CITY OF ALBUQUERQUE

July 8, 2011

**Re: Altura Additional Parking
Grading and Drainage Plan
Engineer's Stamp dated 6-14-11 (H17/D071)**

PHASE I: shall include 25 additional parking spaces as shown in View A, B, D and part of C.

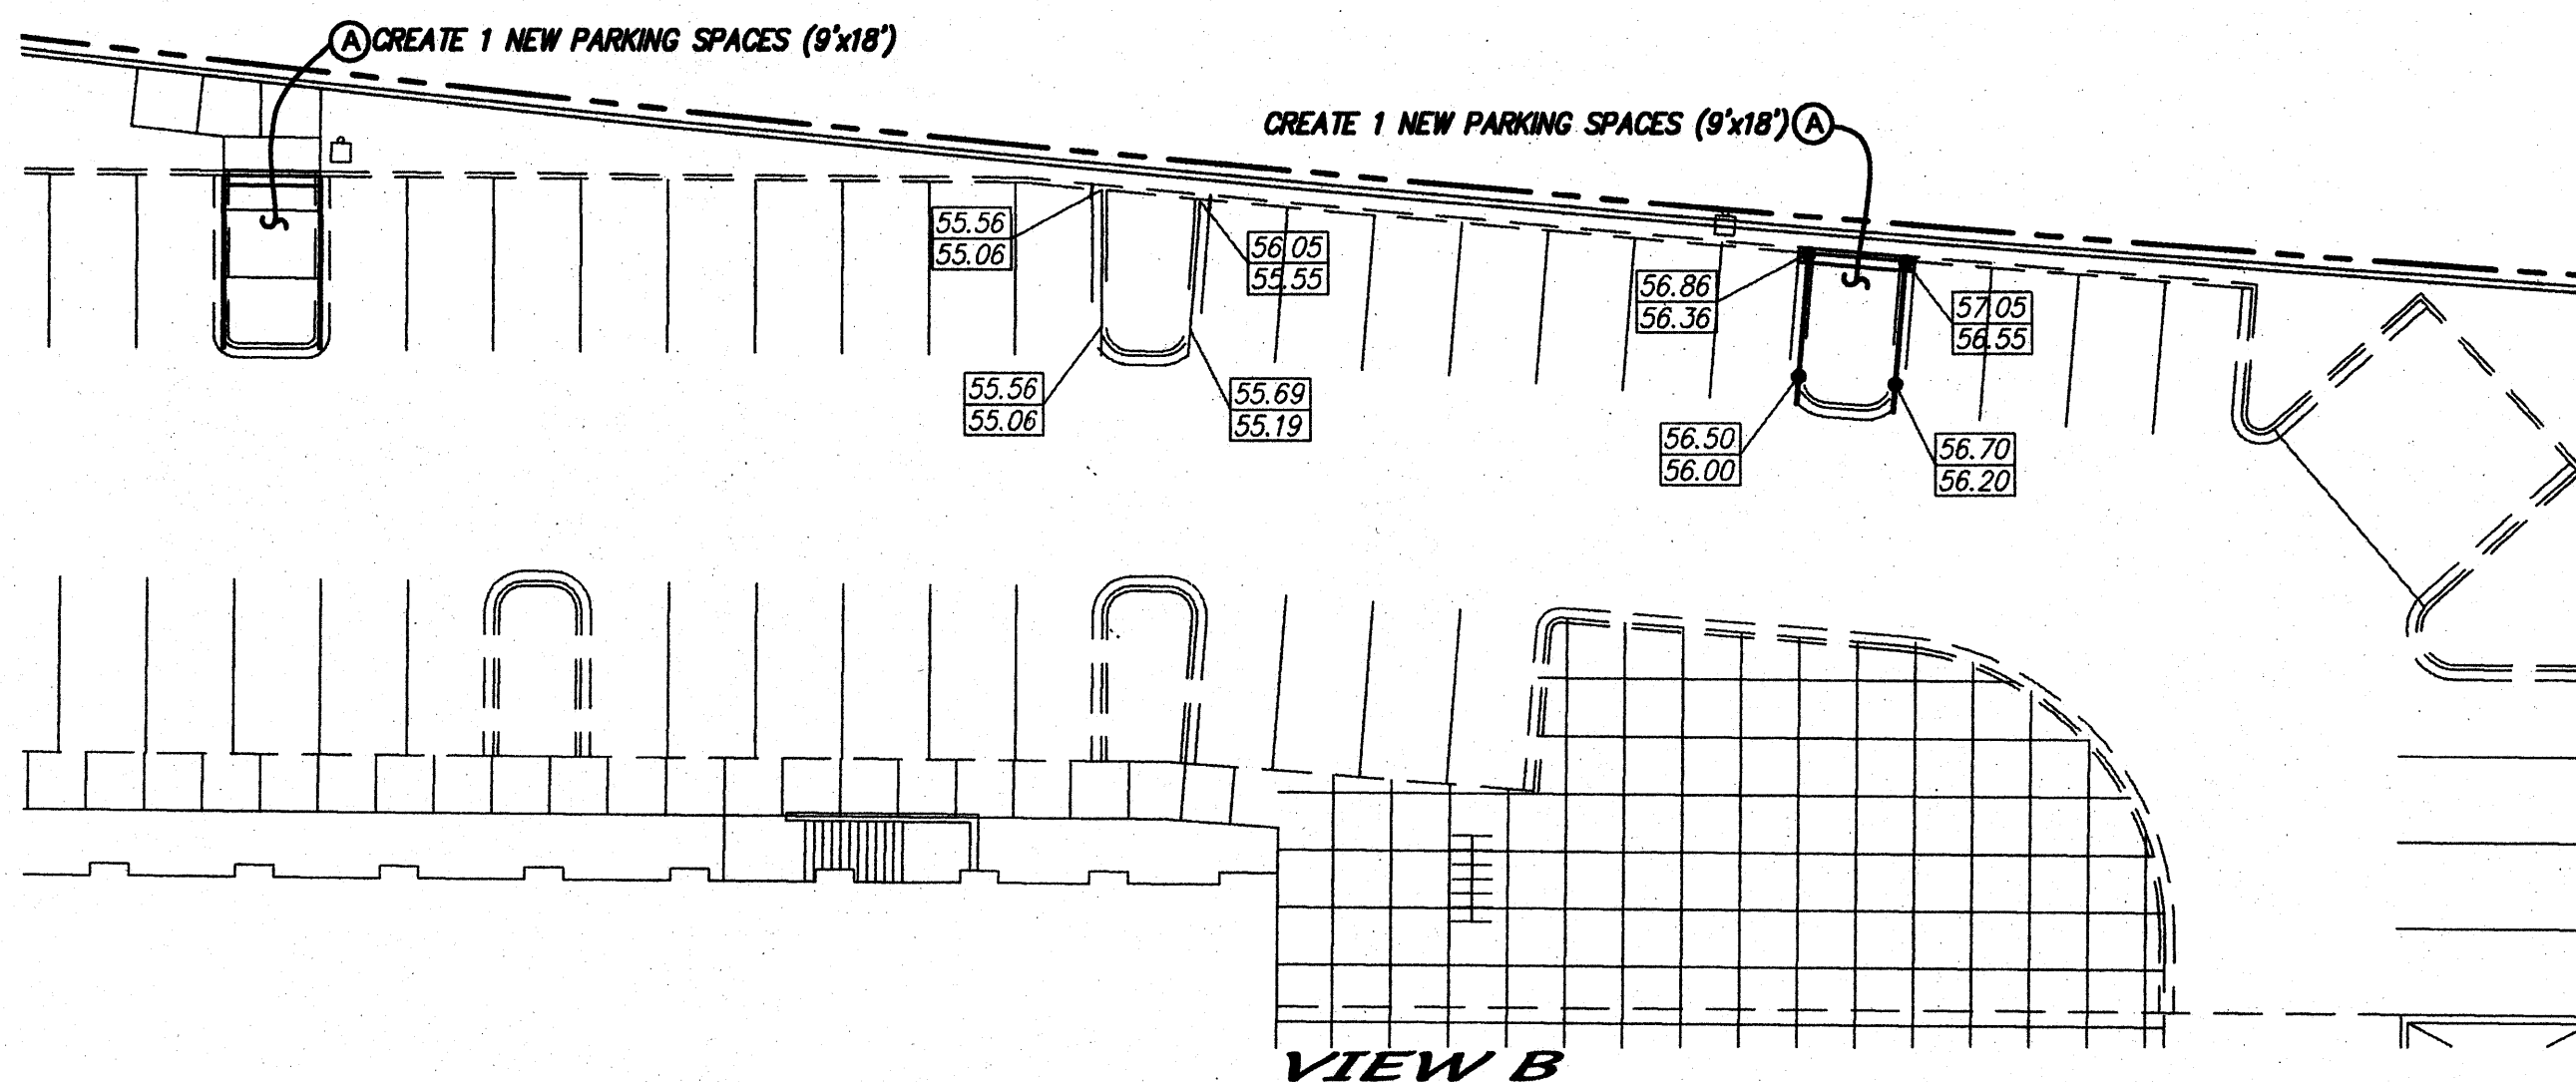
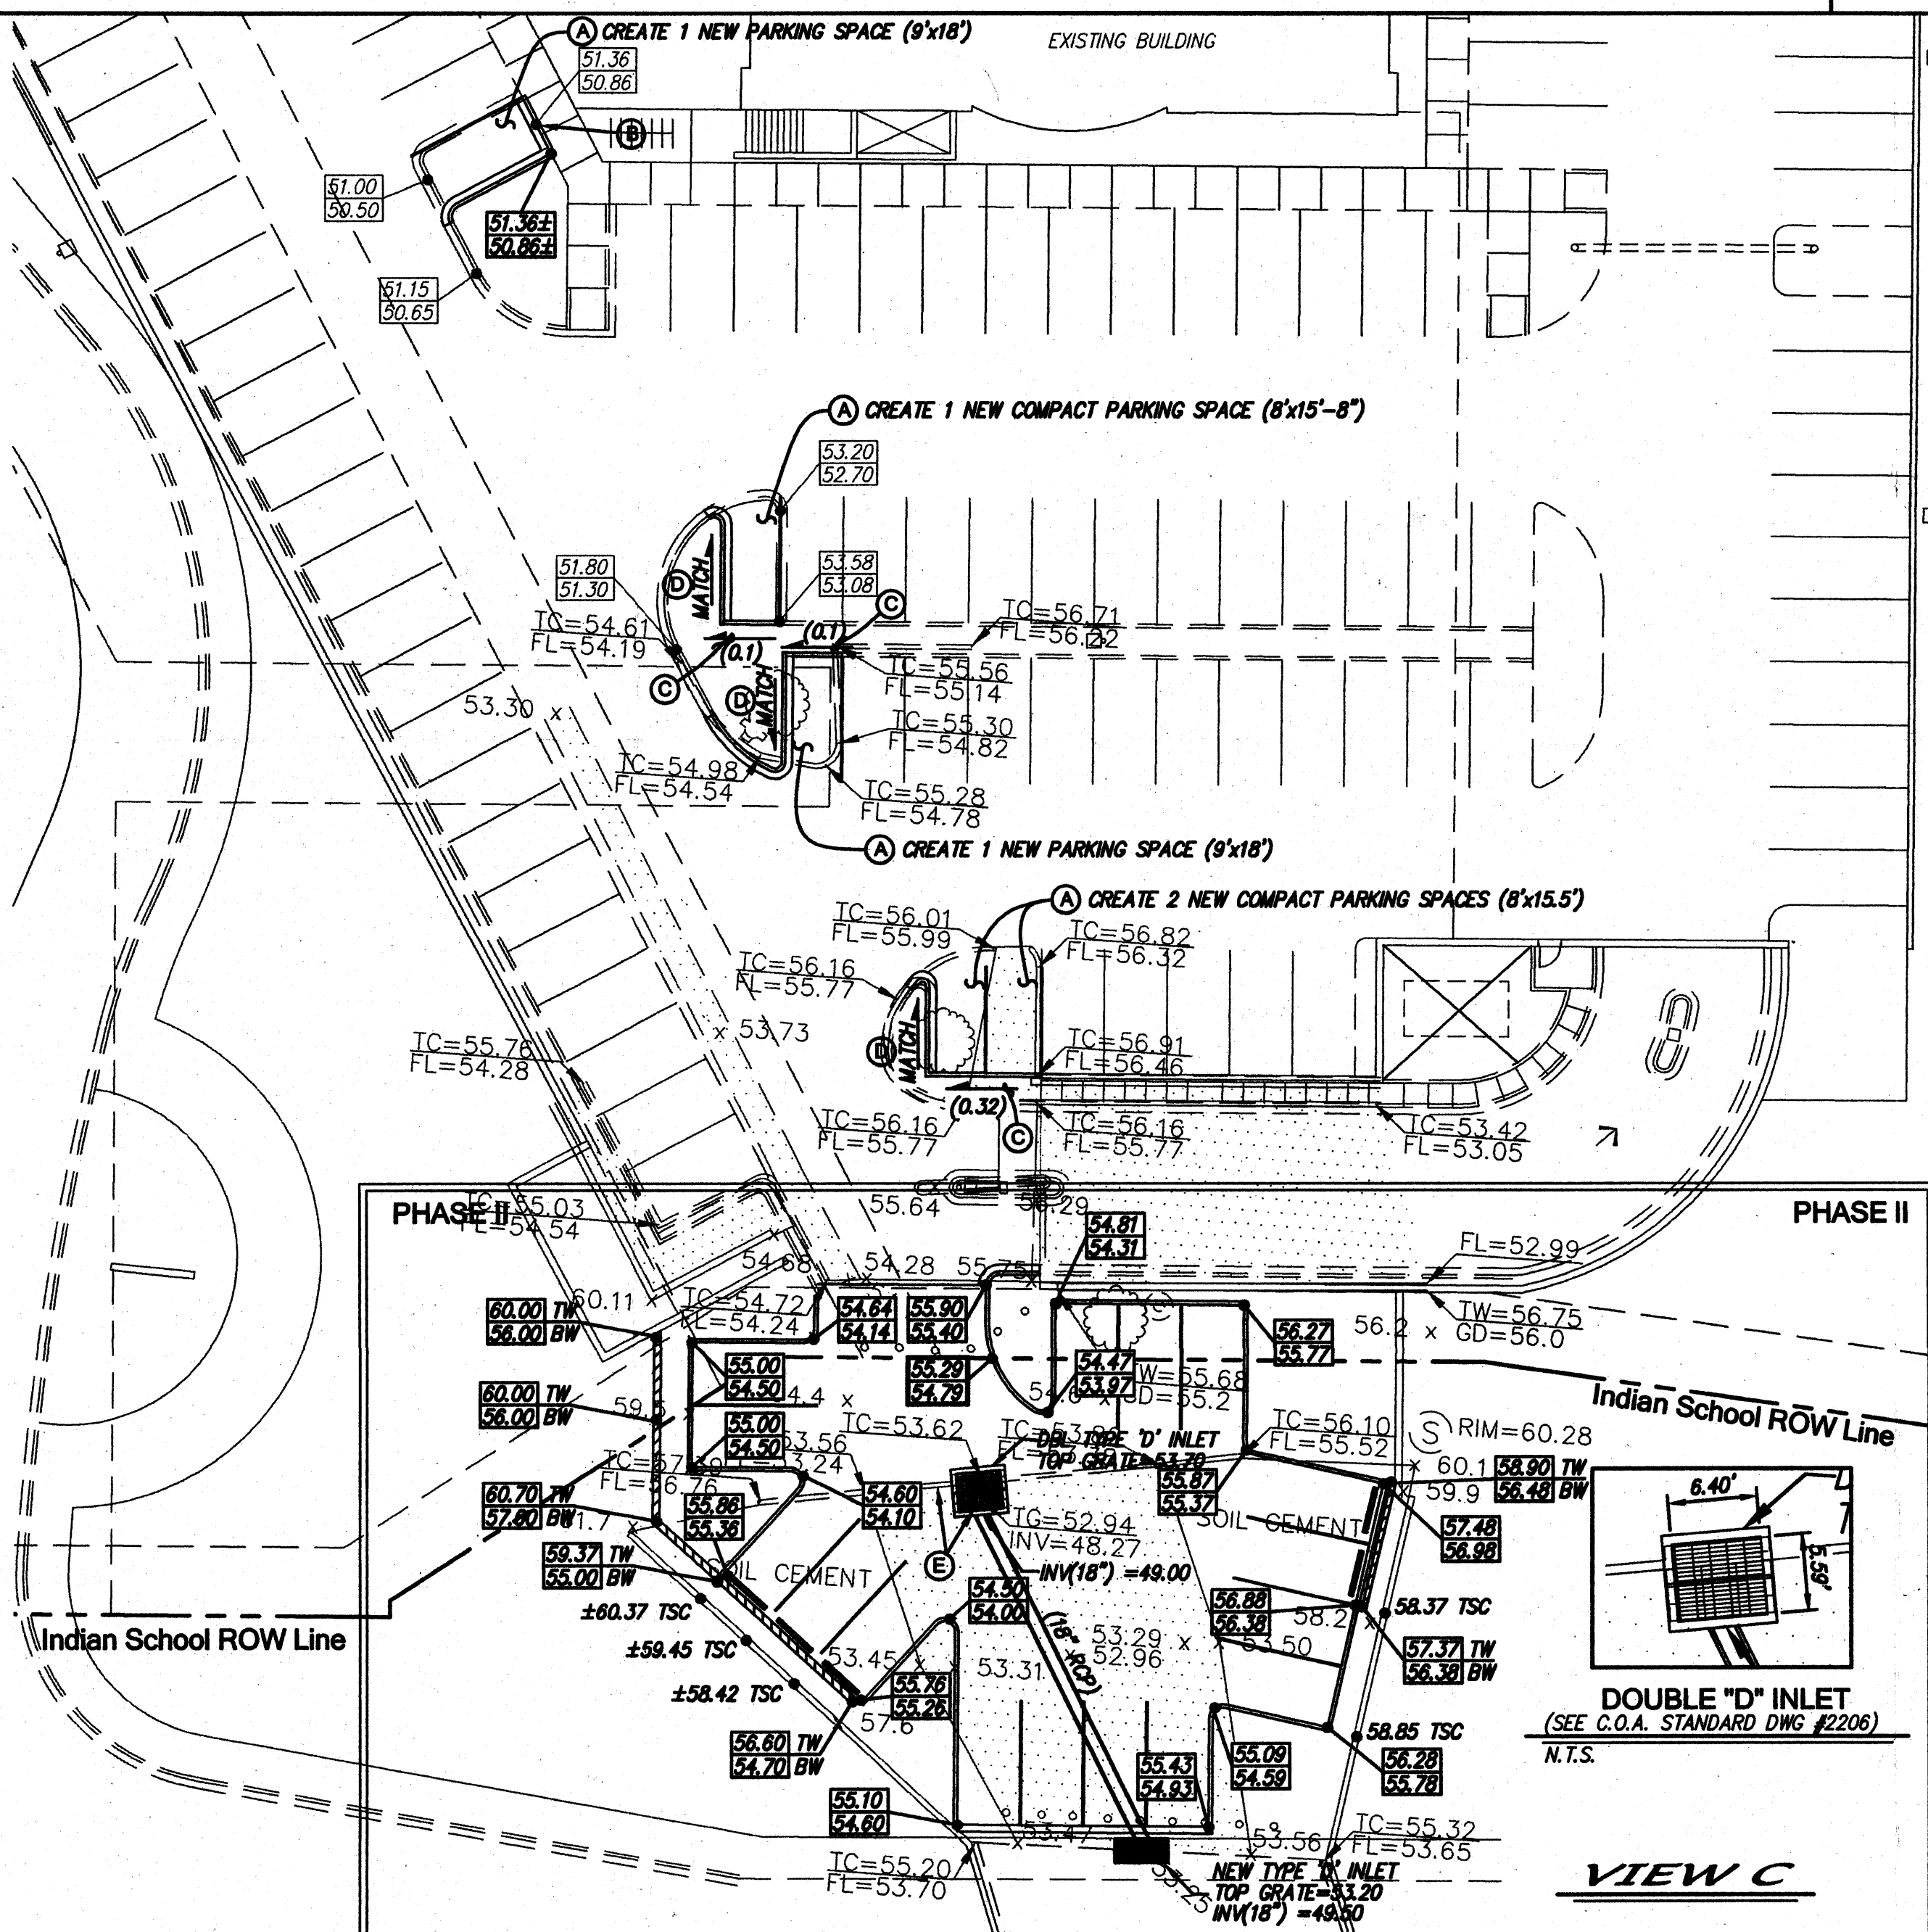
- What are the existing flows and the new flows?
- At this time Hydrology is only reviewing phase 1. Before phase 2 can be reviewed, a vacation of right of way for Indian School Road is needed.

Hydrology is requesting that proposed landscape areas be depressed to retain/infiltrate the rain that falls on them.
